From: Sue Howell
Sent: 14 August 2019 16:06
To: Planning.Responses <Planning.Responses@arun.gov.uk>
Cc: David Easton <David.Easton@arun.gov.uk>
Subject: RE: Planning Consultation on: BE/29/19/PL

Comment from Greenspace

APPLICATION **BE/29/19/PL**

Description of Works: Erection of 99 No. dwellings together with landscaping, open space & associated works. Access to be taken from New Barn Lane(Alternative application).

Tree Pit Detail: Soft Landscape

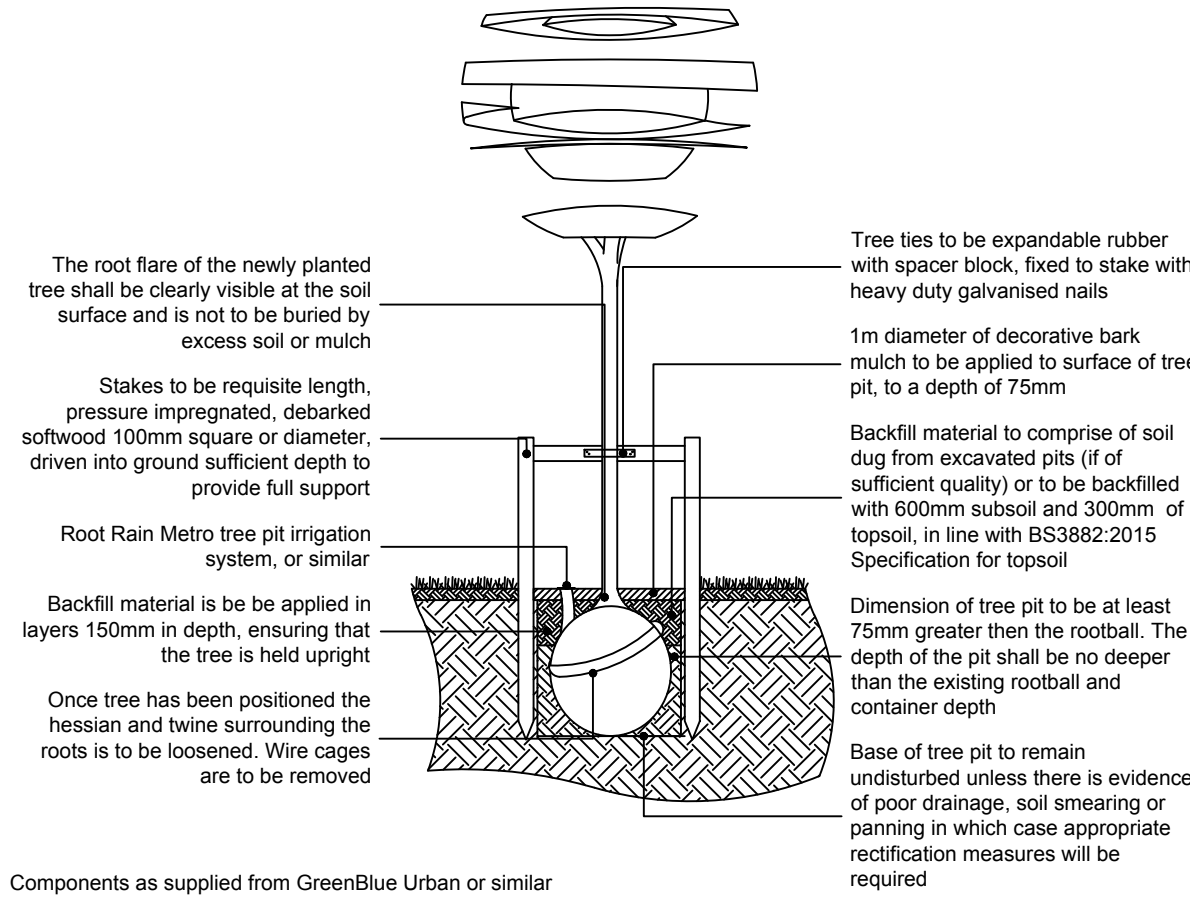
The landscape information contained within landscape proposals LIN22251 11D Sheets 1-6 is detailed and provided in sufficient detail re species choice, quantities, planting densities and size at time of planting. I am pleased to see that detail has been proposed for the tree pit formation with the incorporation of tree support components such as those supplied by GreenBlue Urban or similar. With the employment of such systems and adequate aftercare support the trees should be given a good chance to establish and flourish. It is encouraging to see the specification of root barriers where there are trees in conjunction with SuDS features, these are to be encouraged and should be beneficial in the long term establishment reducing root inclusion conflict.
